Our reference: ECM: 9288030  
Contact: Gavin Cherry  
Telephone: 02 4732 8125

22 September 2020

**Response to Request for comment on SSD 9522 - Kemps Creek Warehouse Logistics and Industrial Facilities Hub -657-769 Mamre Road, KEMPS CREEK NSW 2178**

LONGITUDINAL SECTION - CL ACCESS RD 1
HORIZONTAL SCALE 1:500
VERTICAL SCALE 1:100

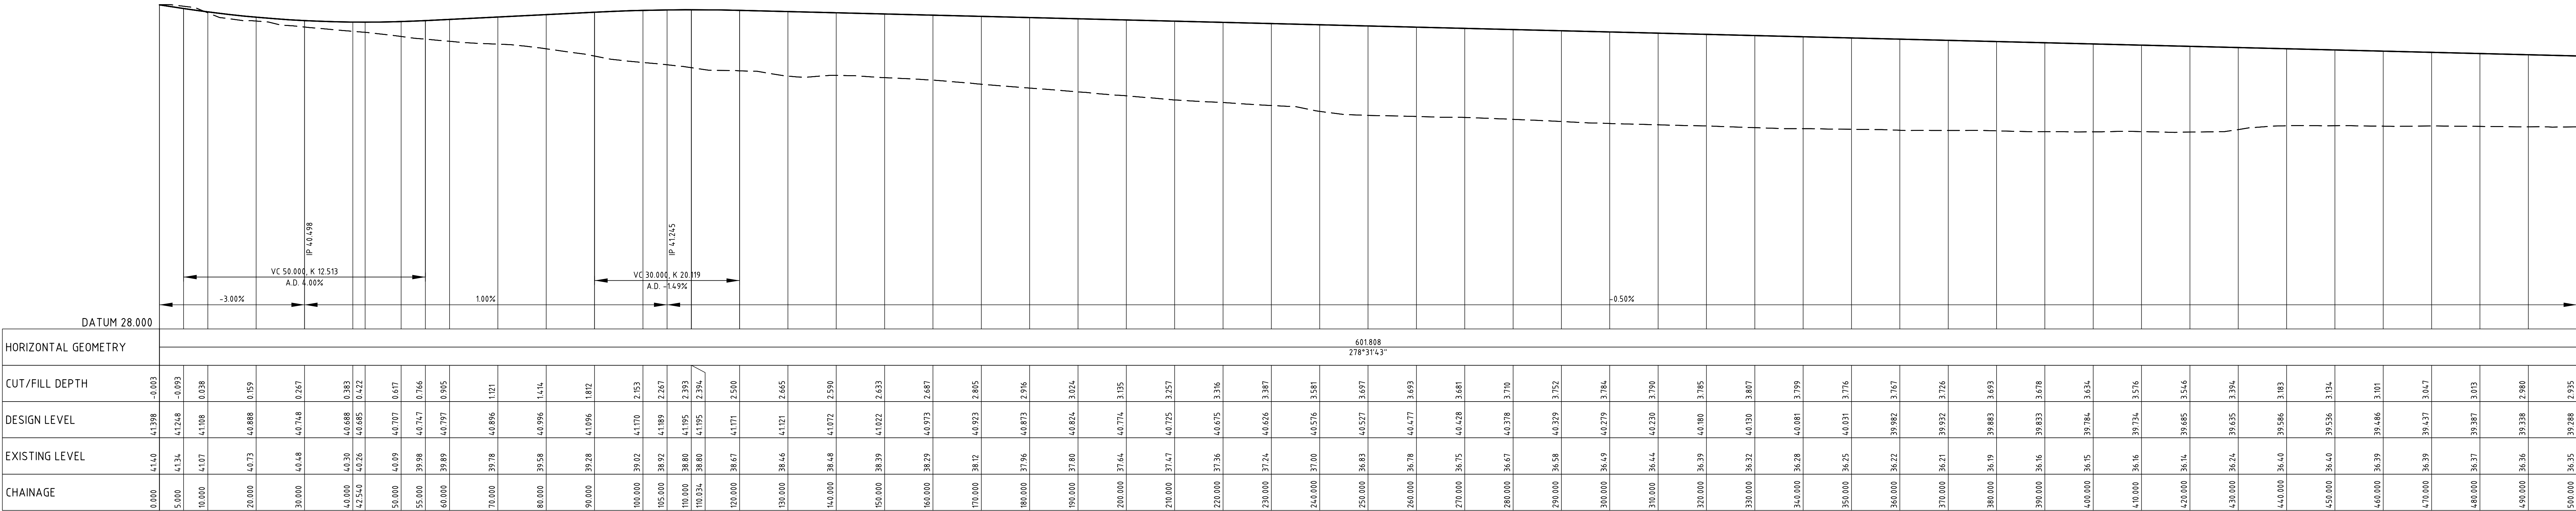
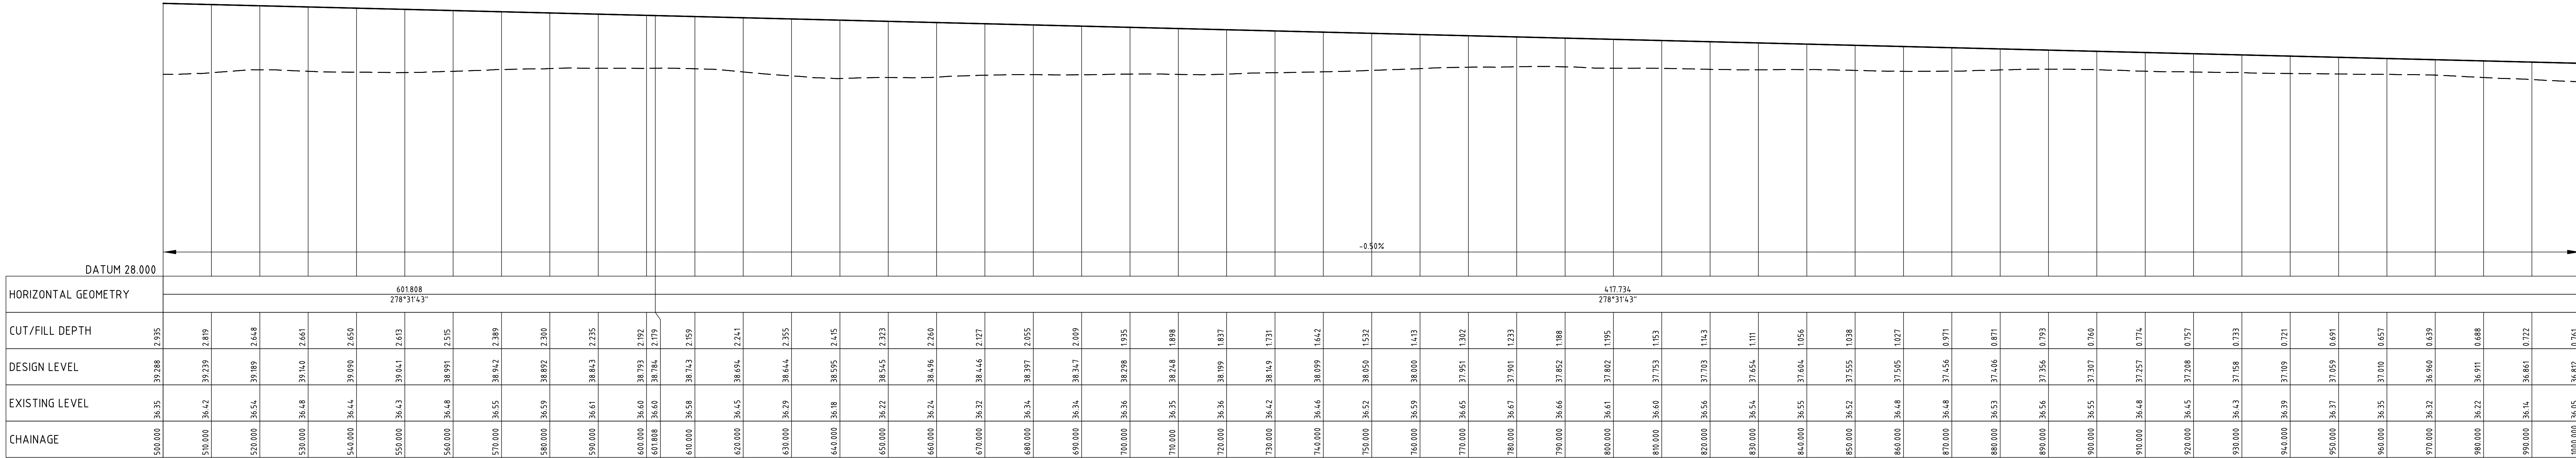
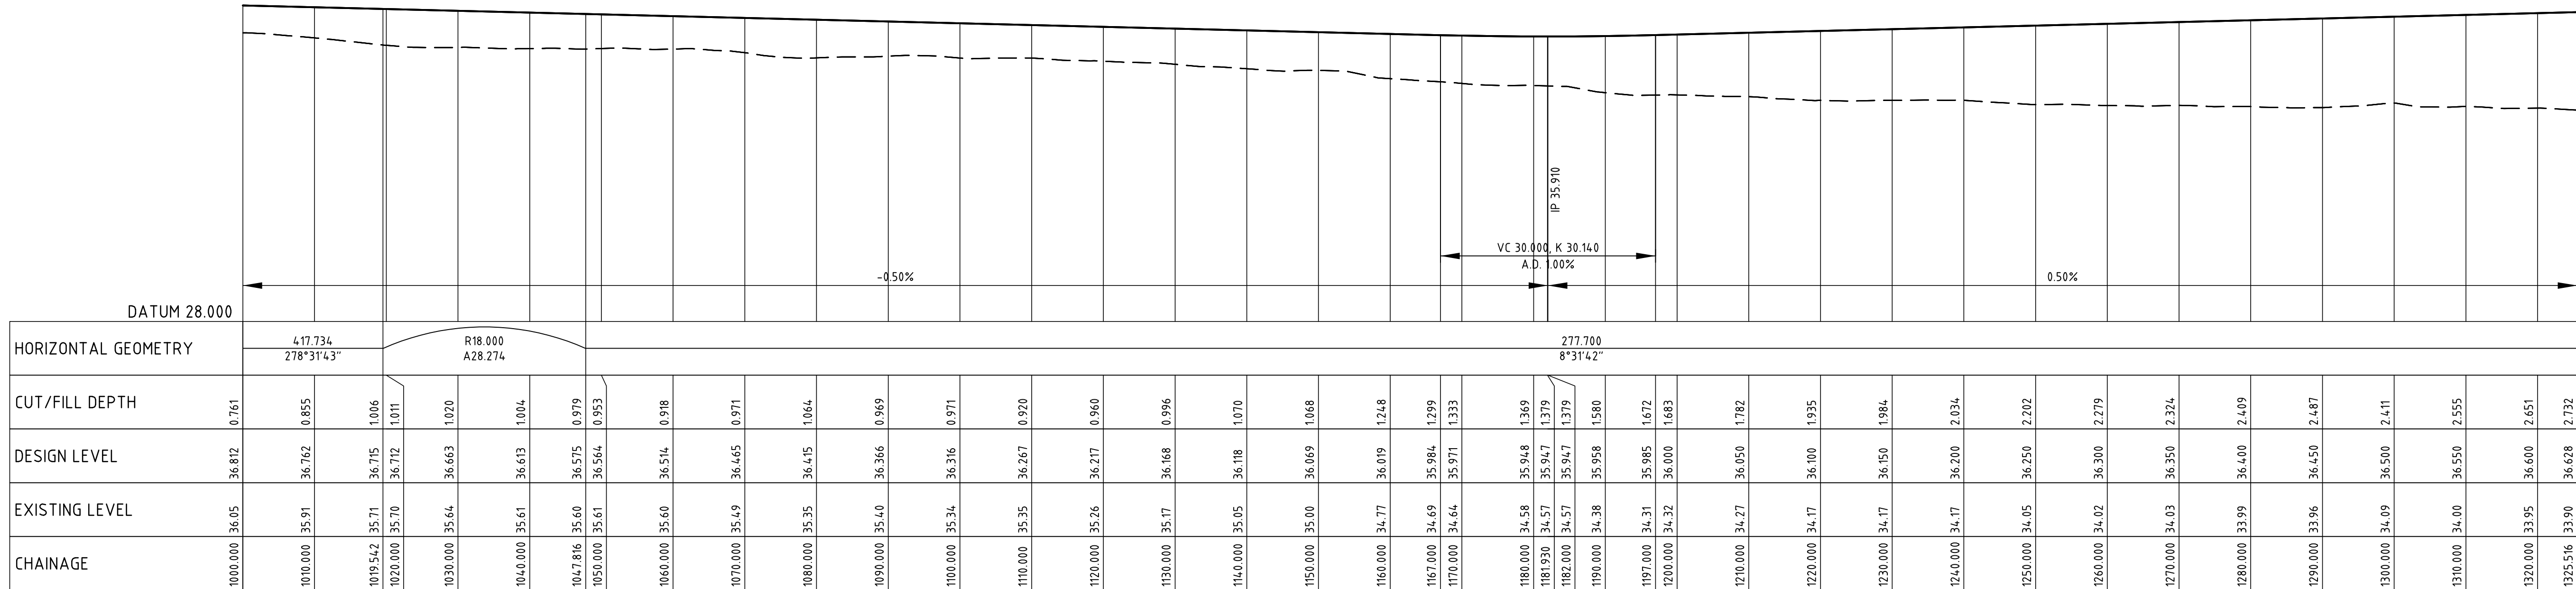
- The Bakers Lane, Bakers Lane / Mamre Road intersection and Mamre Road frontage levels and road reserves should be subject to acceptance by TfNSW and Council (as roads authority), and be informed by detailed plans, long sections and cross sections that define the required alignment, intersection works, major drainage and structures, widening, landscaping, earthworks, acquisition and levels. It is noted that this could potentially be addressed through conditions of consent through the construction certification process.

TYPICAL CROSS SECTION - ACCESS ROAD 1
SCALE 1:50

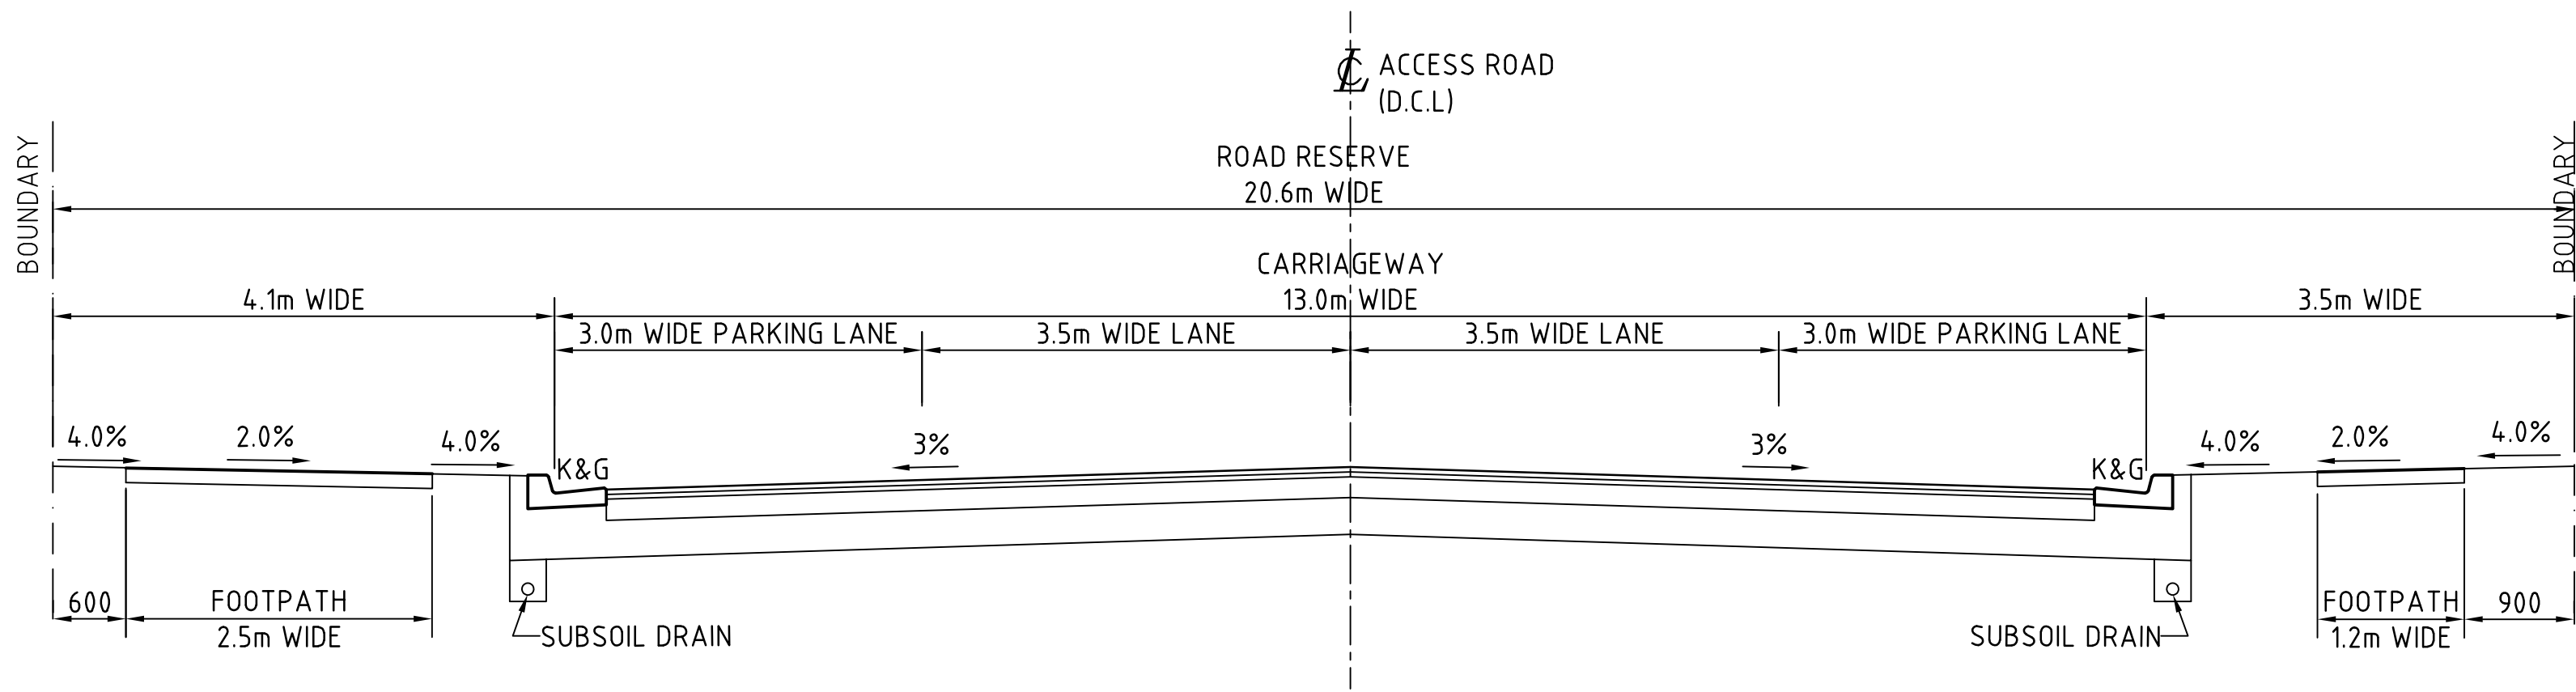
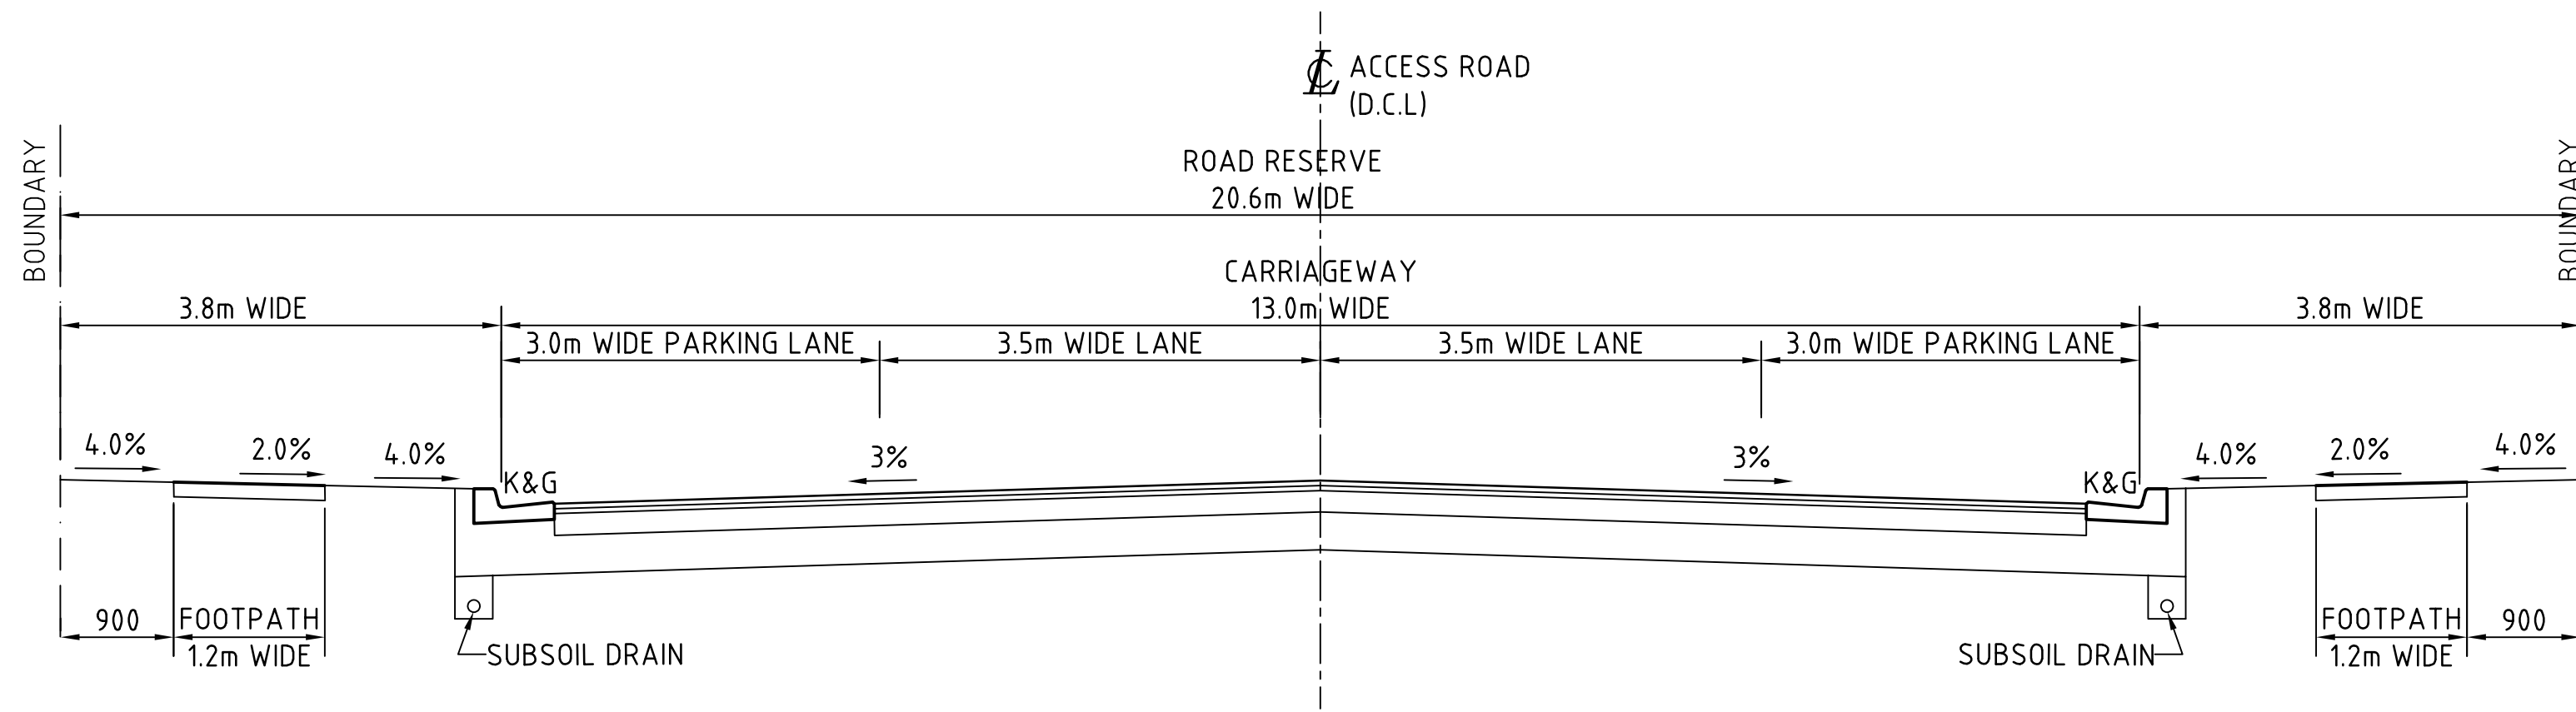
- It is also recommended that the development road cross sections should make provision for:
  - 5 metre wide verge with 1.5 metre wide path both sides and be widening to 6 metre wide verge with 2.5 metre wide shared pedestrian / bicycle path along the southern side of Bakers

- 4.25 metre wide parking / travel lane both sides
- 3.5 metre wide travel lane both sides
- 5.0 metre wide landscaped centre median with 3.5 metre wide Right Turn Lanes and 1.5 metre wide median at any required additional right turn lanes
- Any required additional Left Turn Lanes are to be 3.5 metres wide and include an additional 2.0 metre wide through bicycle lane beside the parking / travel lane in accordance with Austroads guidelines.
- All lanes are subject to additional widening to accommodate the turn paths of B-triple heavy vehicles at curves and intersections as determined by turn path design.
- Pedestrian kerb ramps and pedestrian gaps in the centre medians shall be provided at all approach road to intersections in accordance with Austroads, TfNSW and Council guidelines and requirements.

The above dimensional recommendations must not be at the expense of the landscaping and landscape setback zones as currently proposed.
